CITY OF ALBUQUERQUE

May 12, 2015

**Re: Del Webb @ Mirehaven Phase I
N-2-A of the Watershed Subdivision
Conceptual Grading & Drainage Plan (H09D017C1)**

DRAINAGE PLAN

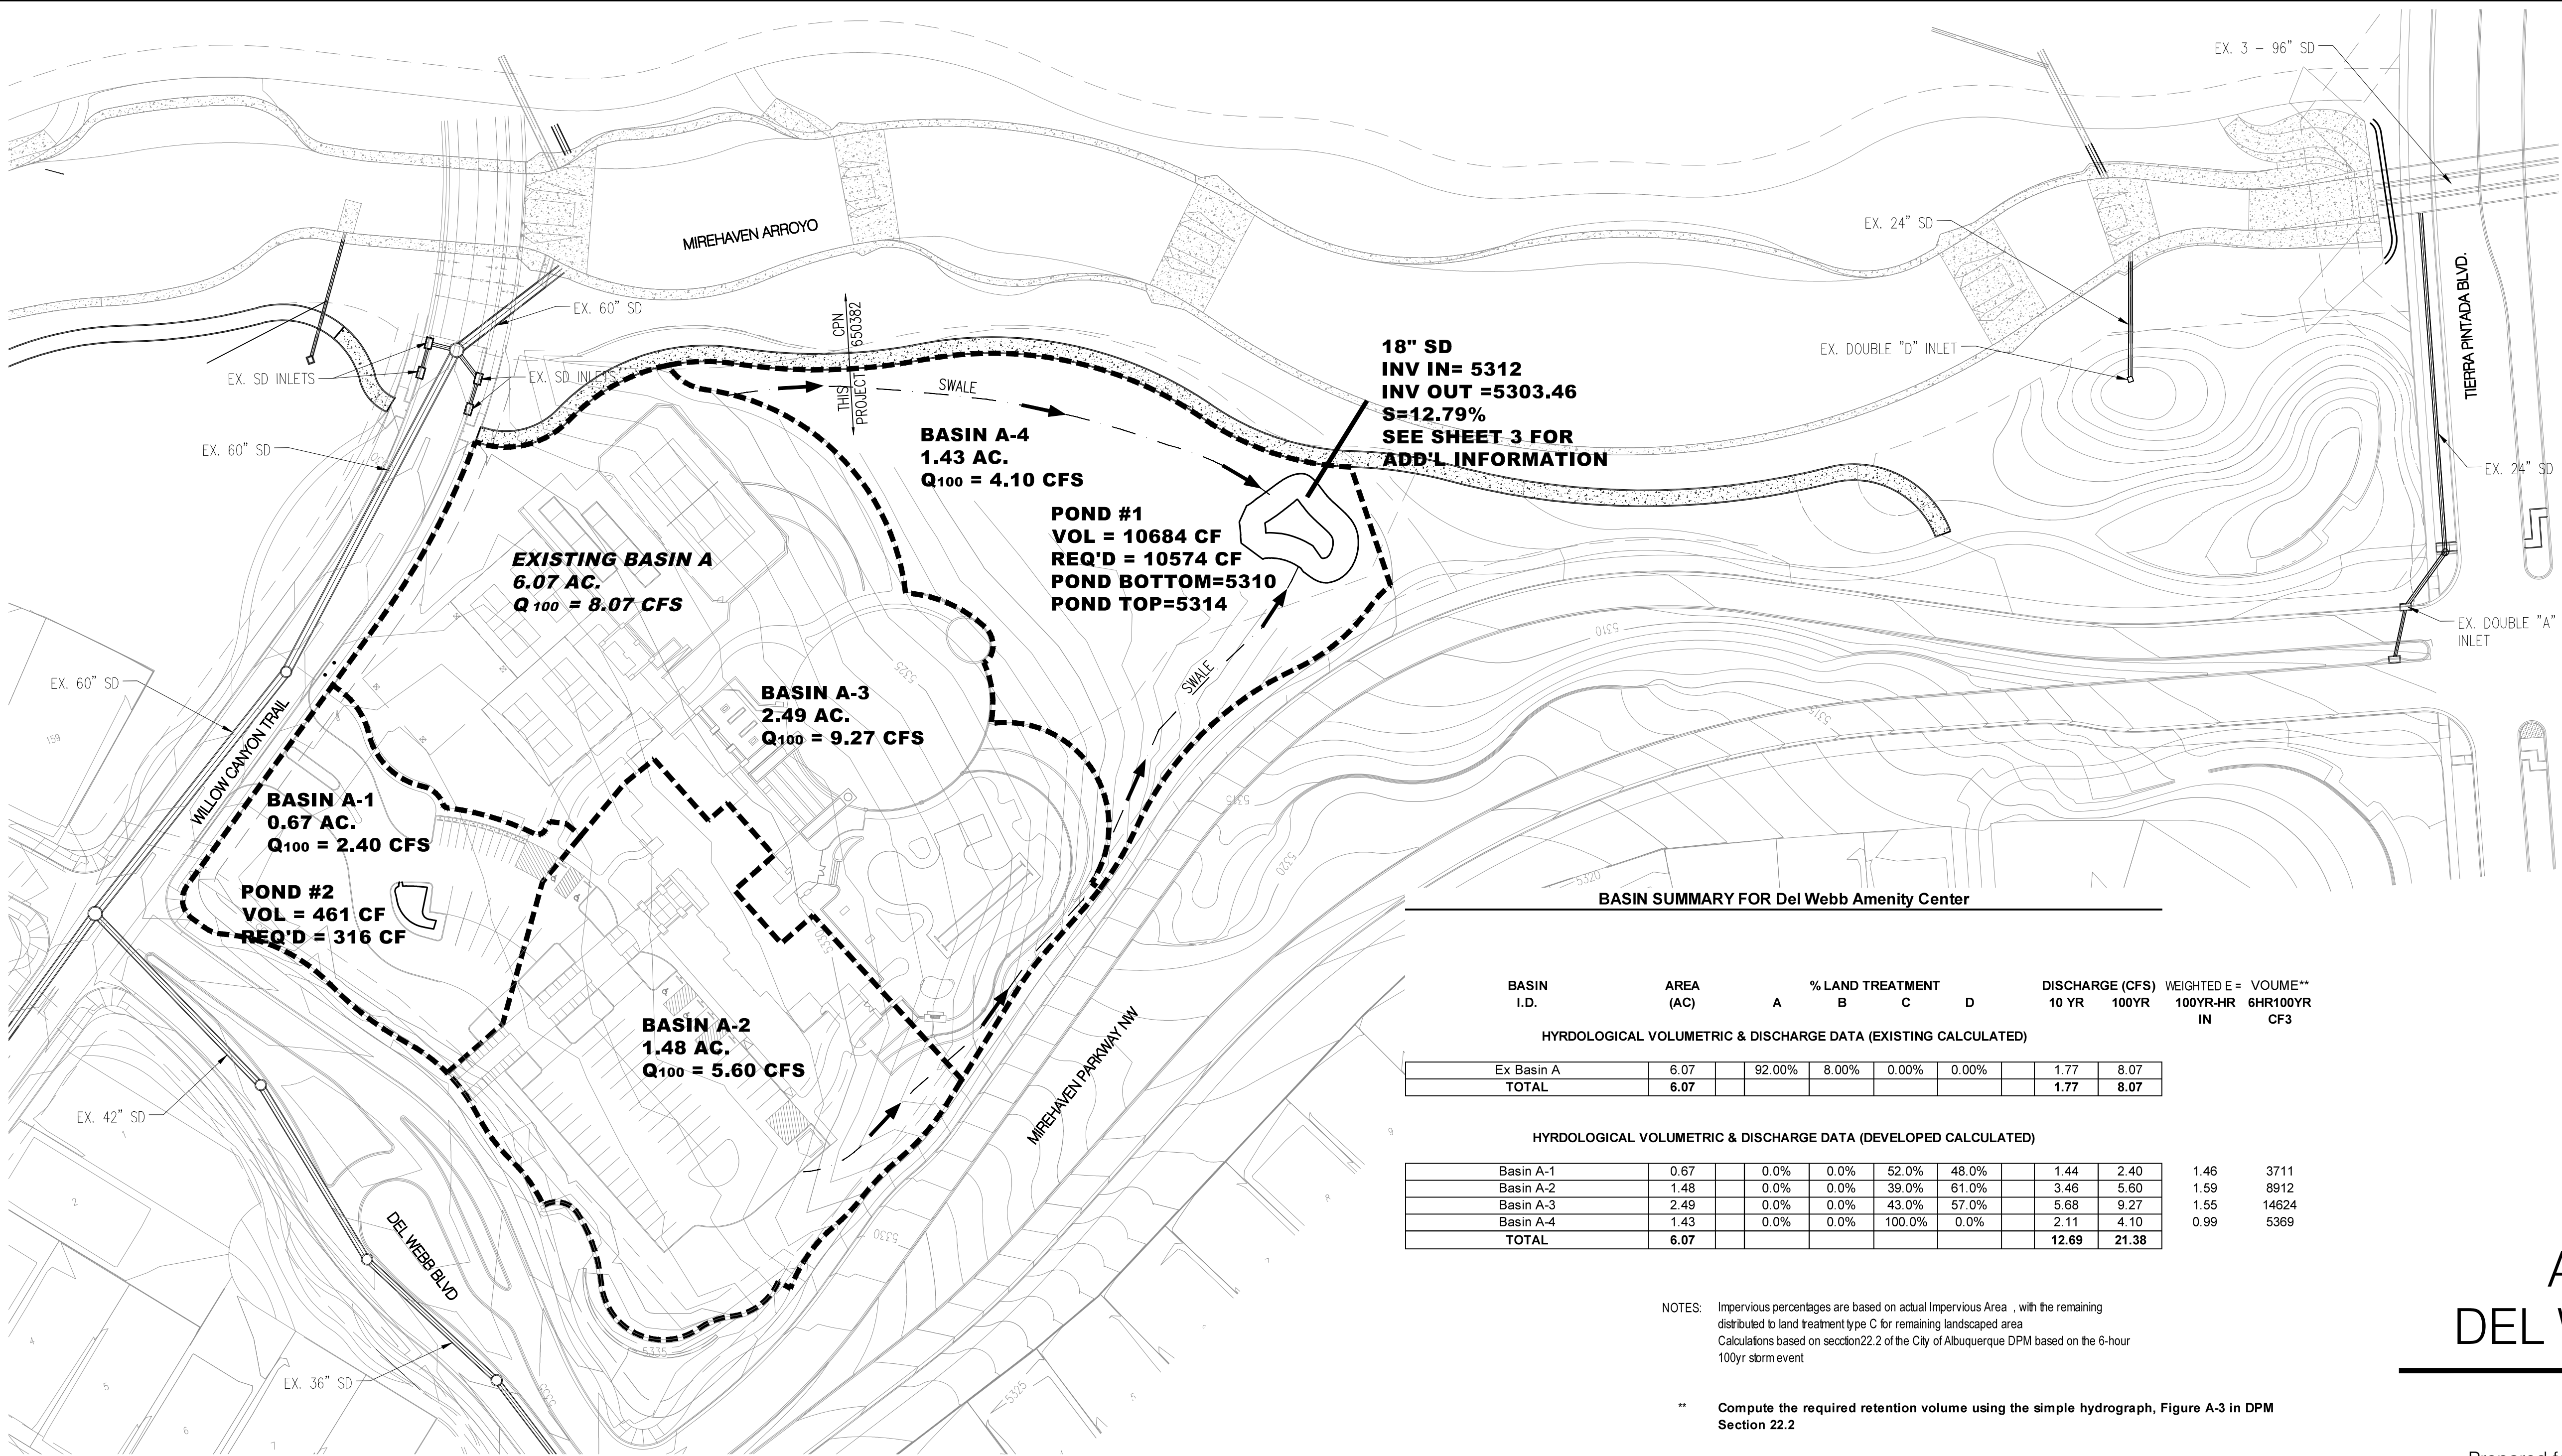
Based upon the information provided in your submittal received 5/8/15, the above referenced plan is approved for Site Plan for Building Permit action by the DRB based on the condition that Basin A-2 is to discharge to pond #2, then to the Mirehaven Arroyo. Pond 1 may serve as a detention pond which discharges to pond #2 via a storm drain or surface channel. Also, show the flood zone for this area.

In general, this site is to discharge to the Mirehaven Arroyo per the Master Drainage Plan.
